RE: Response to Submissions, Eastern Creek Quarter Stage 3 Concept Plan (SSD-10457)

Ethos Urban has prepared this letter on behalf of Frasers Property Australia (Frasers) in response to the Department of Planning, Industry and Environment's (DPIE) letter dated 11 March 2021 and the associated submissions received during the exhibition period of SSD-10457 relating to the Eastern Creek Quarter Stage 3 Concept Plan.

Figure 4: Vehicle access

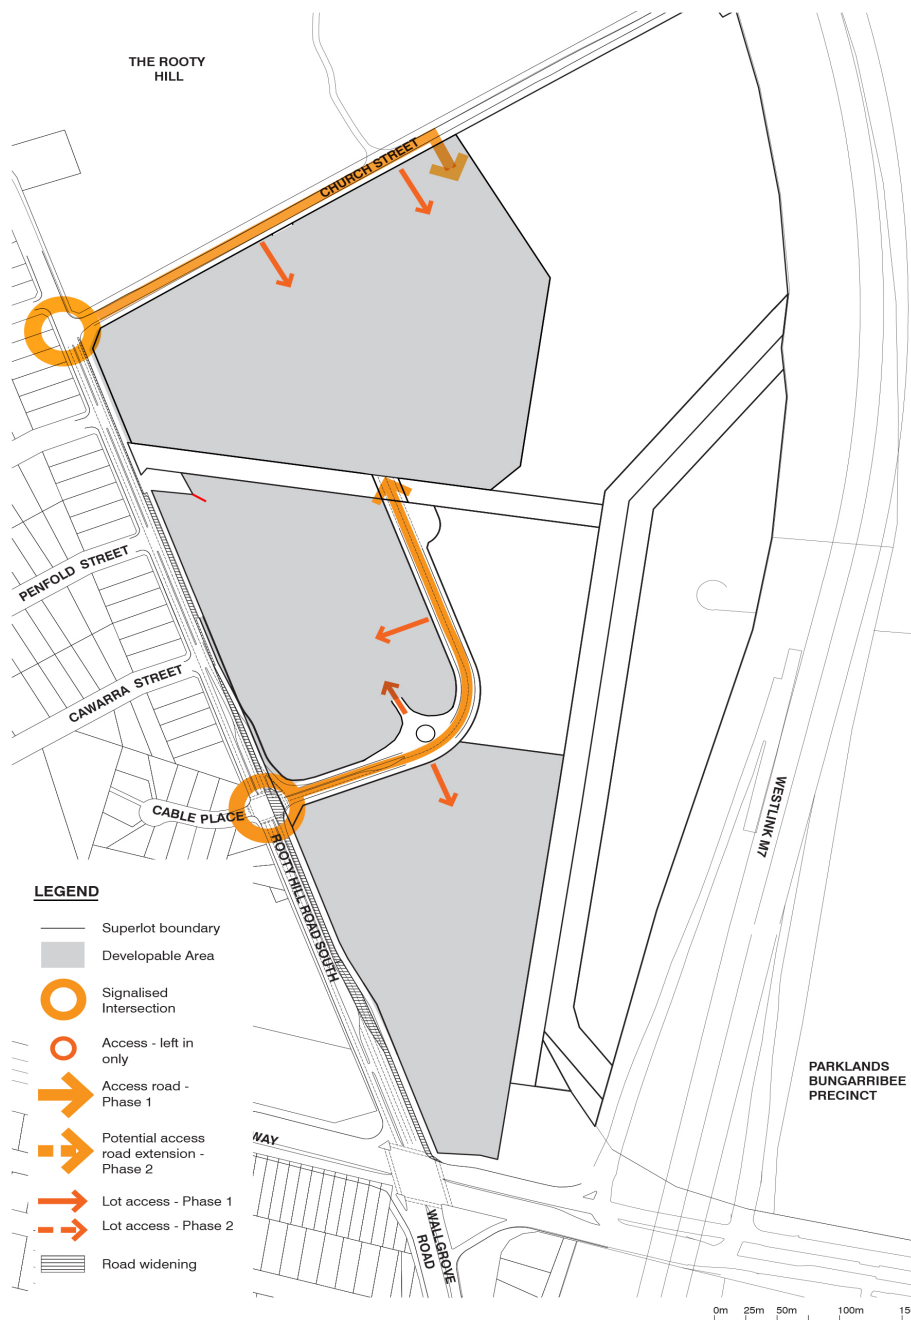
b) Section 1.1 Introduction, update the purpose to be specific to Lot 3	Section 1.1 of the Lot 3 Guidelines has been updated accordingly
c) Figure 4 – identify the loading access from Beggs Road	Figure 4 has been updated to identify the loading access points

Figure 5: Pedestrian Access

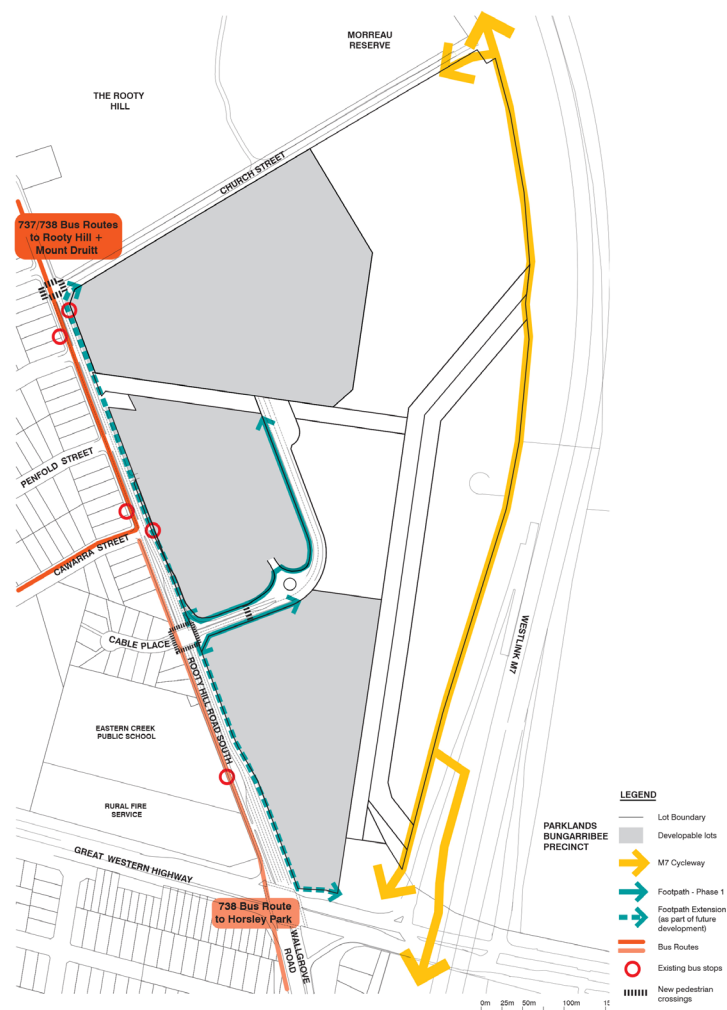
d) Figure 5 – confirm if a footpath will be provided in front of Lot 3 along RHRS and Church St and update section 2.2.	A shared footpath and bicycle path will be provided along RHRS and a footpath will be provided along Church St. Section 2.2 has been updated to clarify this.
